Tree Work Application Decision Notices

NOTICE OF REFUSAL OF CONSENT TO FELL AND/OR PRUNE

Application Number: 2024/92570

At: 33A, Church Lane, Clayton West, Huddersfield, HD8 9LY

Tree Protection Plan to BS5837:2012 at:  
33a Church Lane, Clayton West

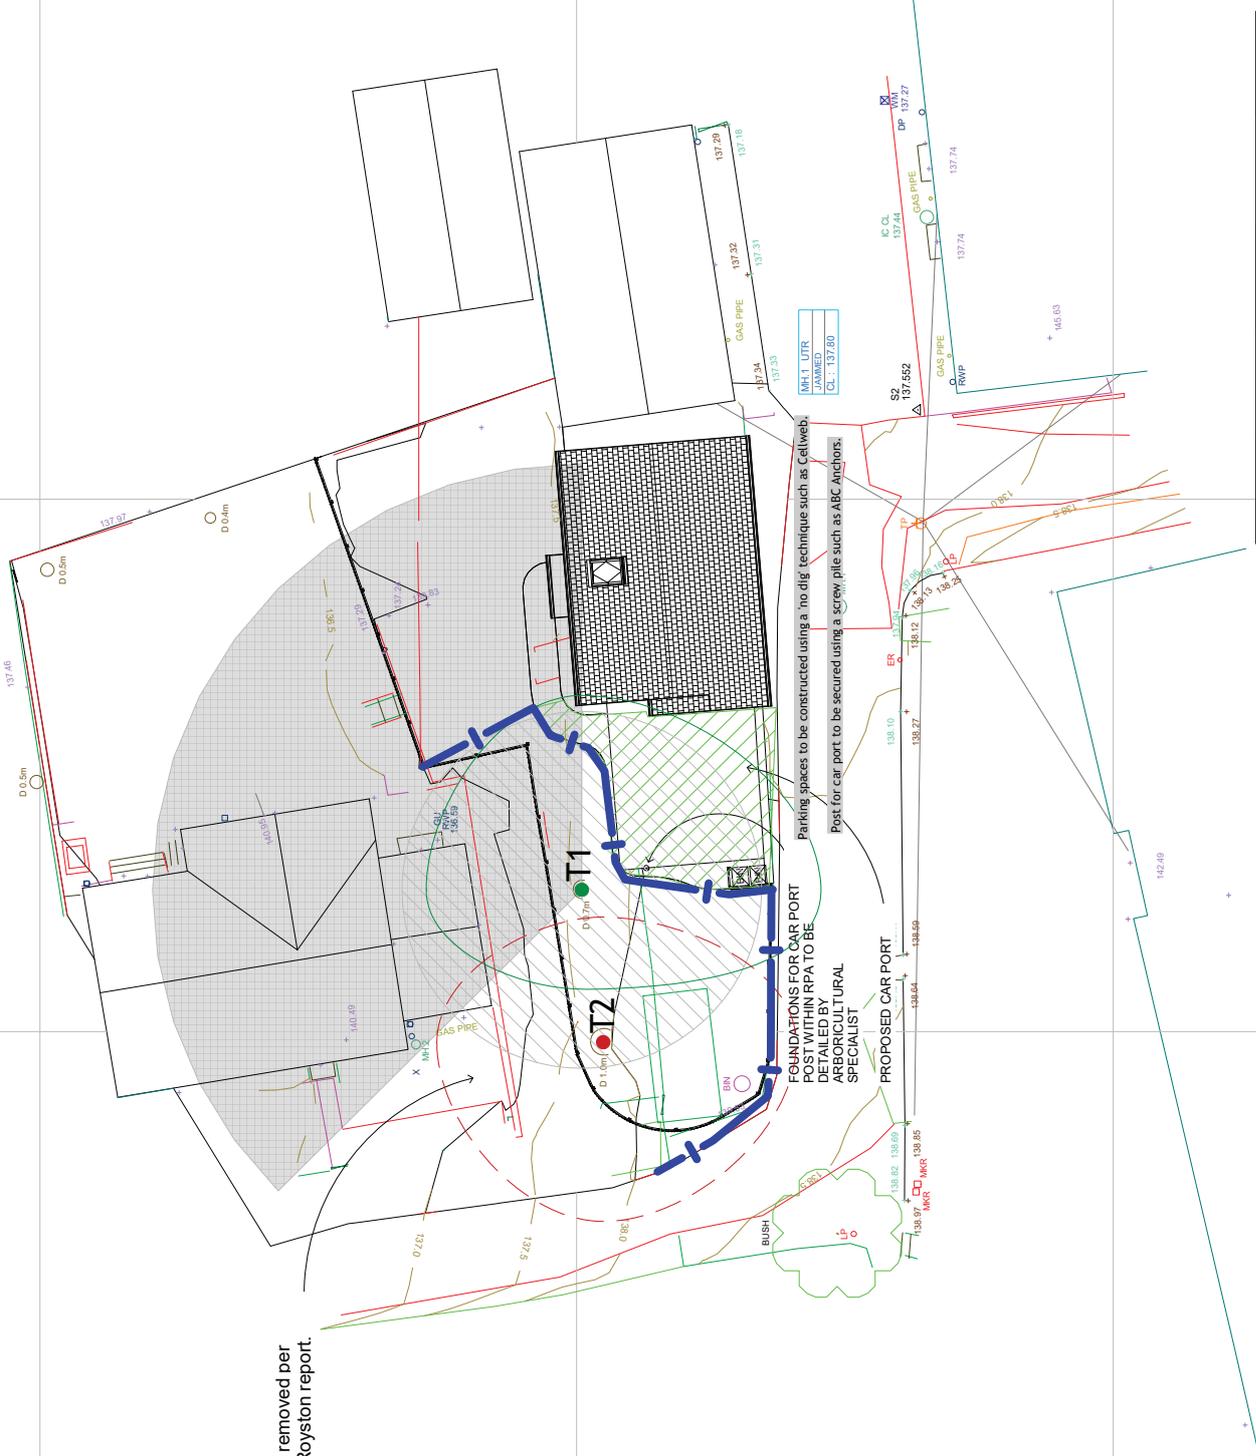
Crown lift of T1 and felling of T2

1. These trees are a prominent landscape feature in the locality and as such contribute significantly to public amenity consequently the grounds for their removal / the pruning proposed must be weighed against the amenity they provide.
2. There was no evidence from an appropriate expert submitted with the application to show that the tree was dangerous as required in section 8 of the application.
3. There was not enough evidence submitted with the application to definitively show the tree poses any abnormal health and safety concerns, it only states the tree is dangerous without evidencing why. However, should additional evidence come to light the Council would be happy to consider a new application supported by this.

4. The Arboricultural impact assessment submitted did not suggest any work is required to T1.
5. The tree T2 is an integral part of a group and its removal would have a detrimental effect on the composition of the group and the amenity it provides.
6. Removal of a protected tree would be a material consideration when deciding a planning application for an extension and if this is required this should be discussed within the context of a full planning application as permission is not guaranteed and therefore would not be a reason to remove the tree under a TWA.
